**Early Grading Drainage Report  
Peaceful Ridge at Fountain Valley Subdivision  
El Paso County, Colorado**

PCD File No: EGP-213

Addendum: February 10, 2022

Appendix C
IRF - Infiltration Reduction Factoring

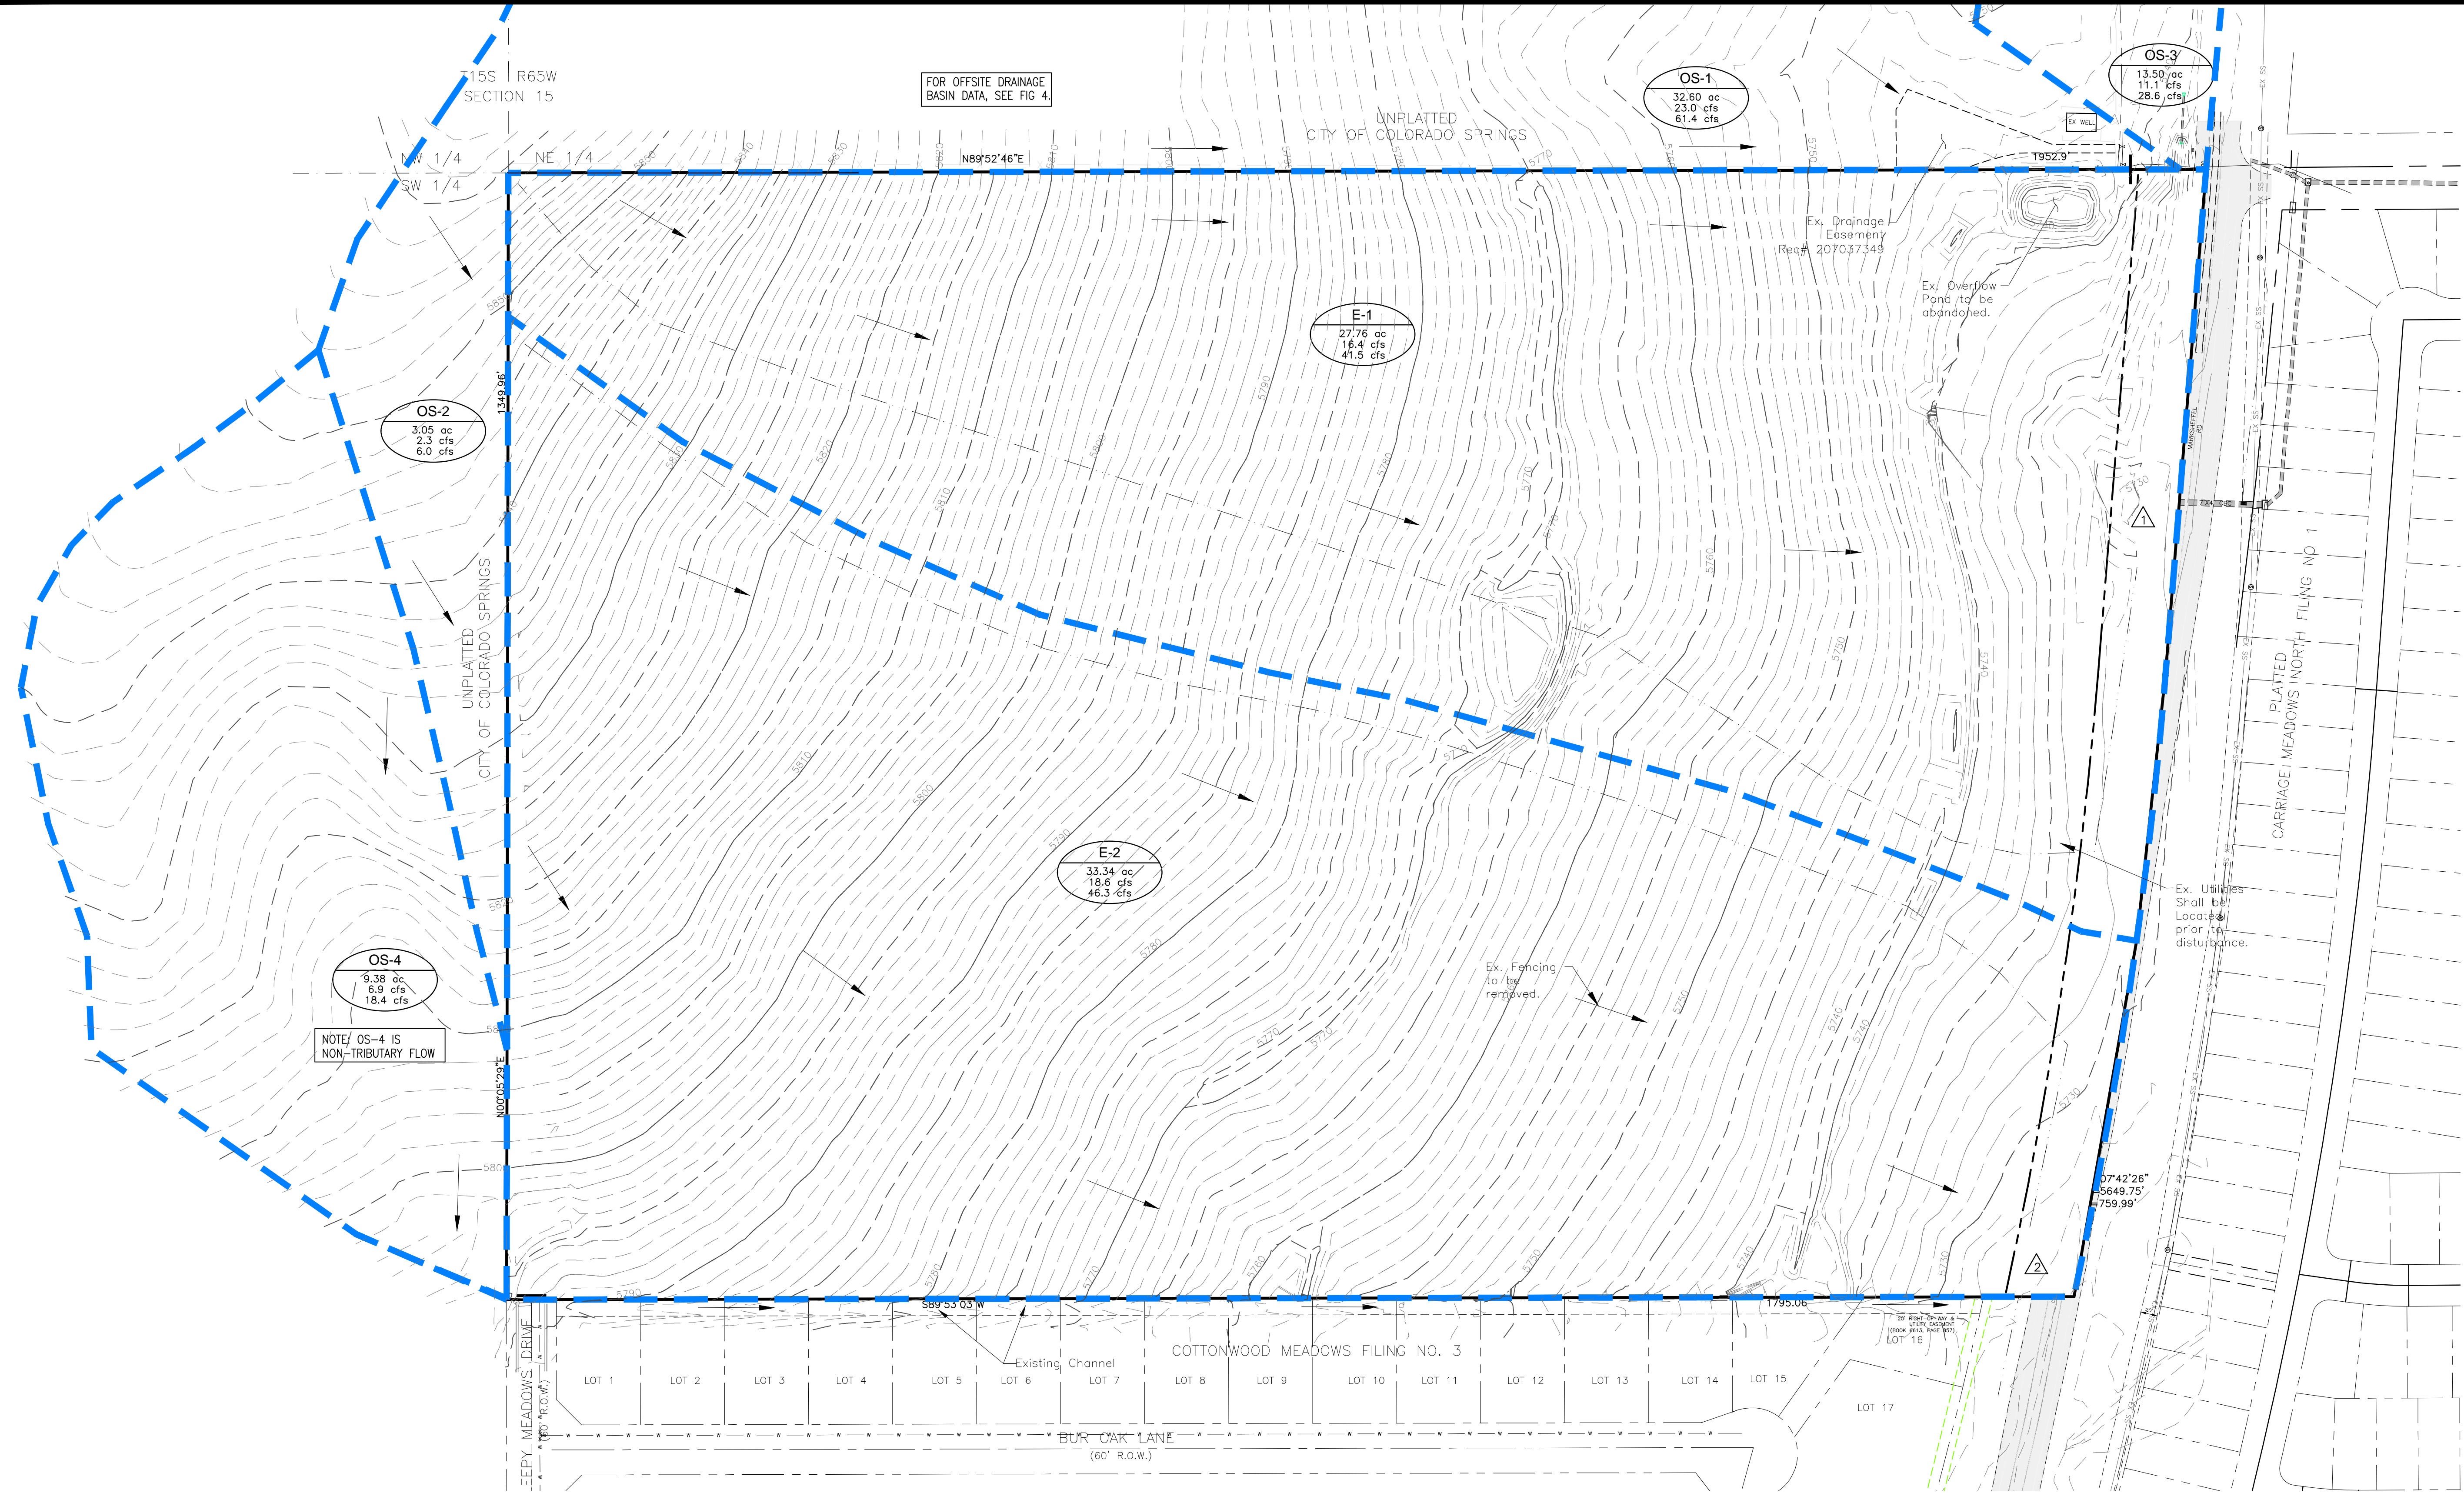
see  
comments  
on IRF-1

see comments on IRF-1

see comments on IRF-1
